11 January 2022

Your Ref: SSD 6964 MOD 4, SSD 6965 MOD 5 & SSD 8892218 MOD 1
Our Ref: R/2016/35/F, R/2020/13/C & R/2015/36/F
File No: 2022/007671

Advice on Modifications – Barangaroo South – Building R4A – SSD 6964 MOD 4 and Building R4B – SSD 6965 MOD 5 and SSD 8892218 MOD 1

GF Landscape Plan approved under S4.55 Mod 2

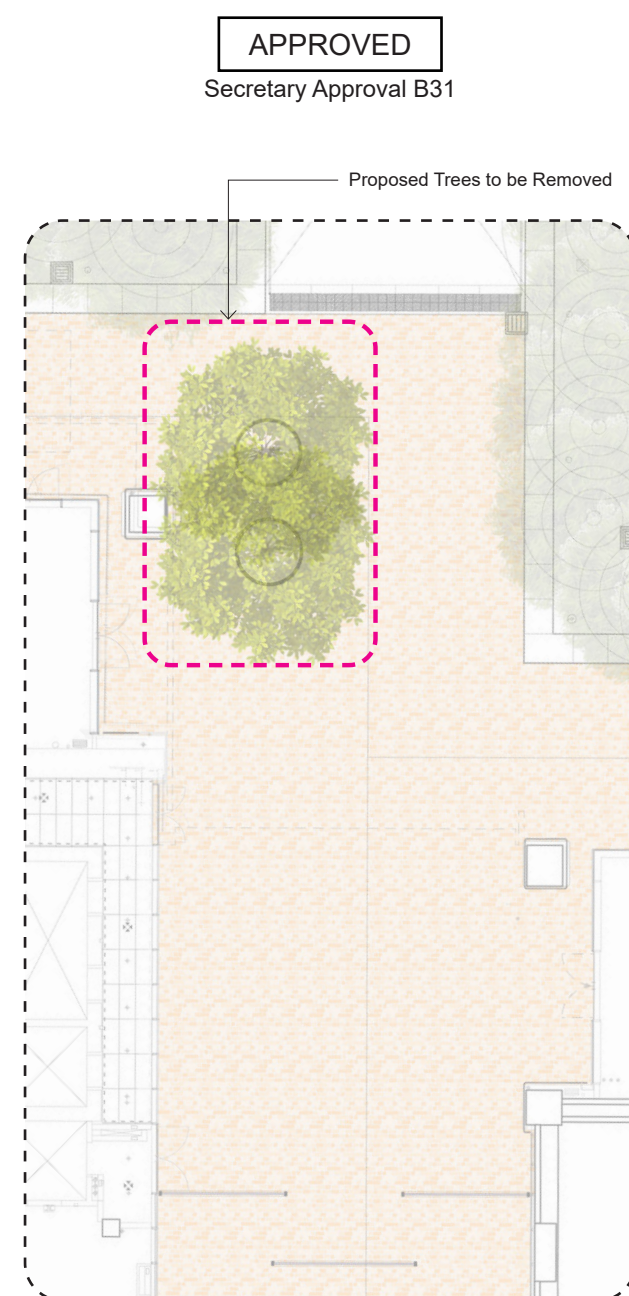
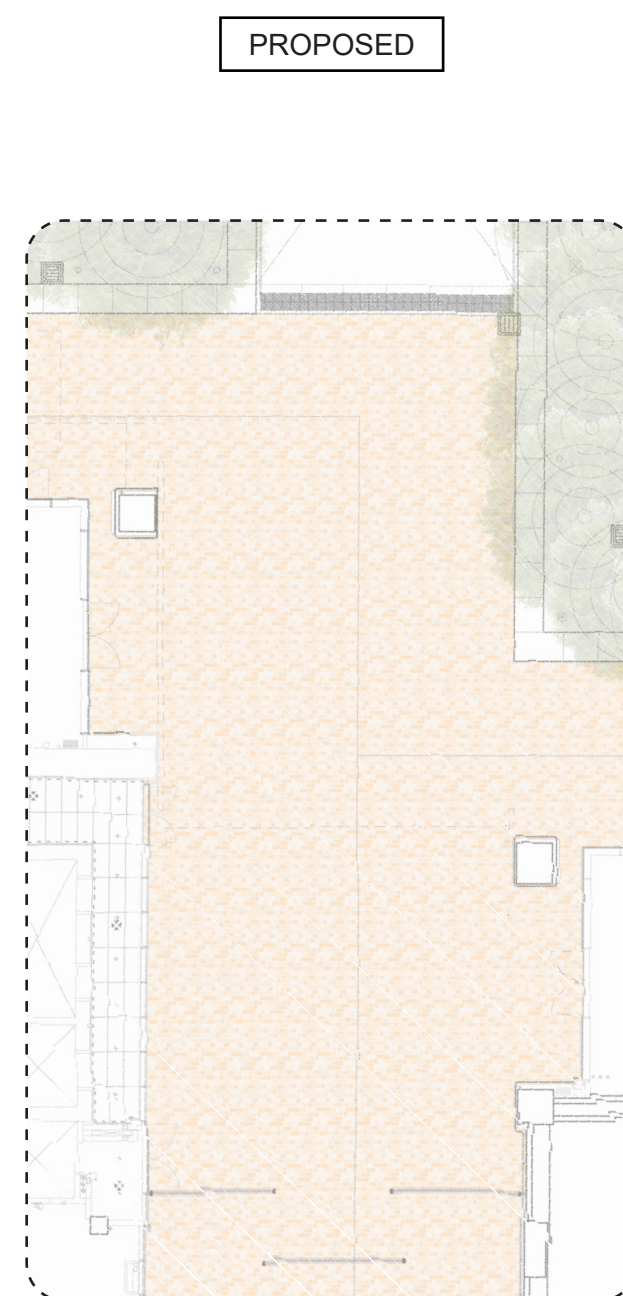
The City questions the need for the removal of the two trees when considering the long-term impacts of the trees on sightlines to Hickson Park. Although it is acknowledged that there is significant planting approved in Hickson Park, any removal of future canopy coverage should be avoided as the benefits of additional canopy to pedestrian amenity outweigh potential impacts, particularly in relation to wind protection and shading in addition to general heat mitigation. As the trees mature, it is unlikely that pedestrian sightlines would be significantly impacted, and reconsideration should be given to maintaining the trees as approved.

Figure 4 | Approved (left) and proposed (right) car park entrance of Building R4B

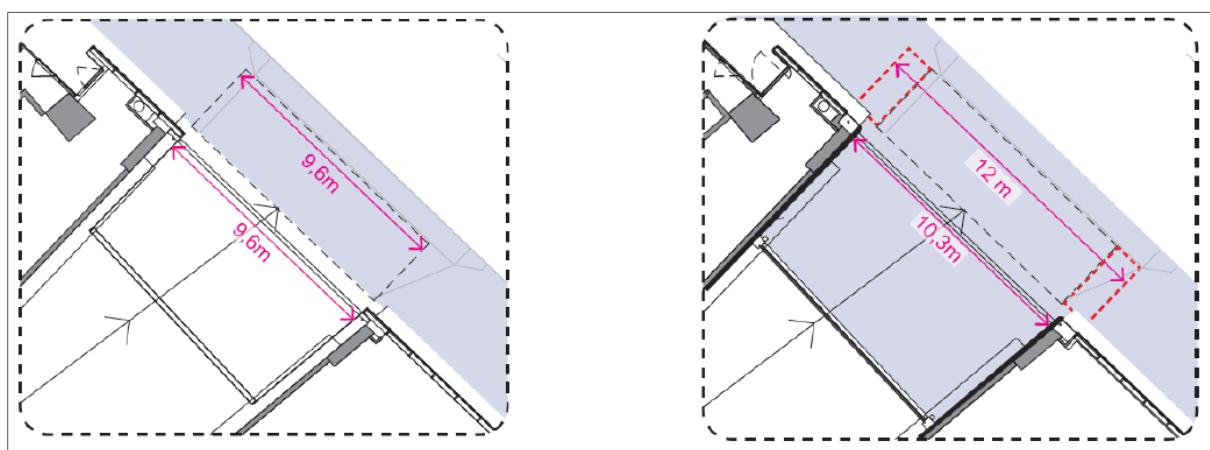
Generally, no objection is raised regarding the proposed modifications. Clarification is sought, however, as to how wide the driveway opening is proposed to be increased. The submitted plans indicate that the ramp door is proposed to be relocated and the facade be updated, and the design report notes the carpark entry width is proposed to be increased, however, no details are provided as to the proposed new width of the opening.

The City generally recommends, as per Section 3.11.11 of the Sydney Development Control Plan 2012, that carpark openings have a maximum width of 4m to ensure pedestrian and cyclist safety and amenity is prioritised. The proposed opening of over 10m is significantly wider than this recommendation and reconsideration should be given to this aspect of the proposal.
